PLAN REVIEW SHEET

Petition #: RZP 2022-087

Address: 9916 Mallard Creek Rd.

Request: UR-2 (CD)

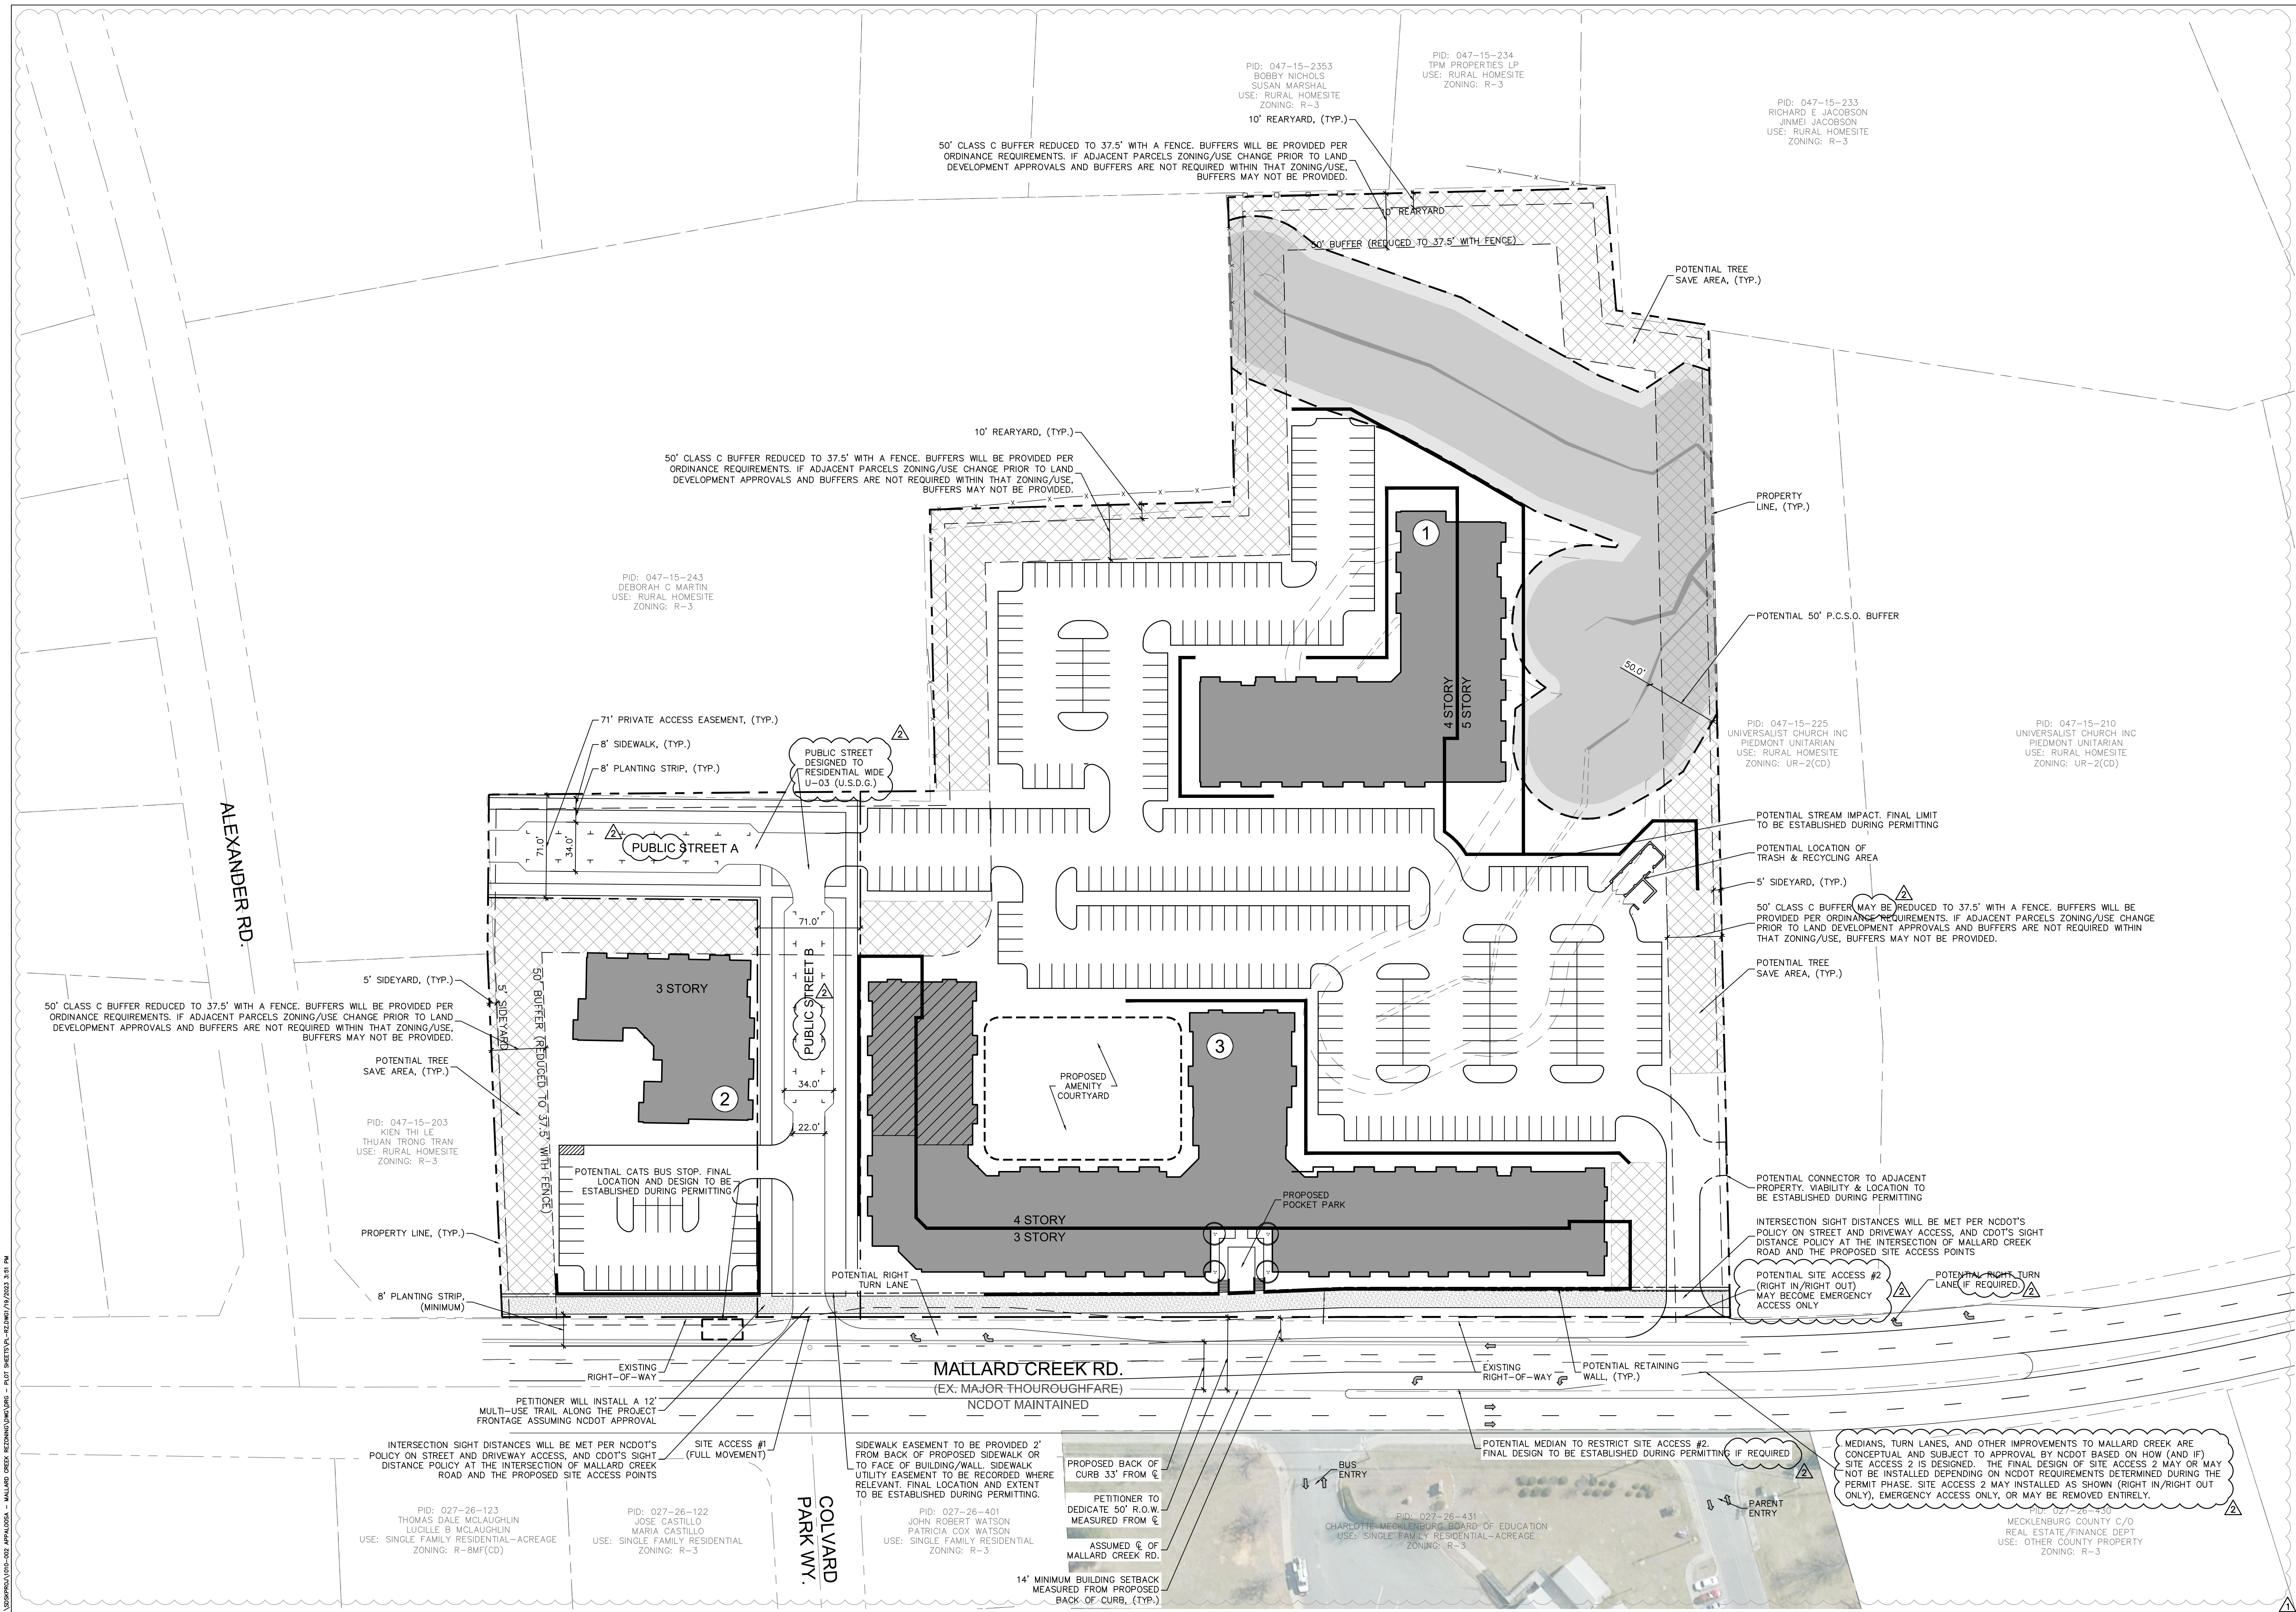
The site is located on CATS local bus route #50 along Mallard Creek Road. The existing bus stop at Mallard Hill Drive will be relocated to frontage opposite Colvard Park Way. CATS requests the construction of ADA compliant bus stop type 60.01A. The final location will be determined during the Land Development plan review process.
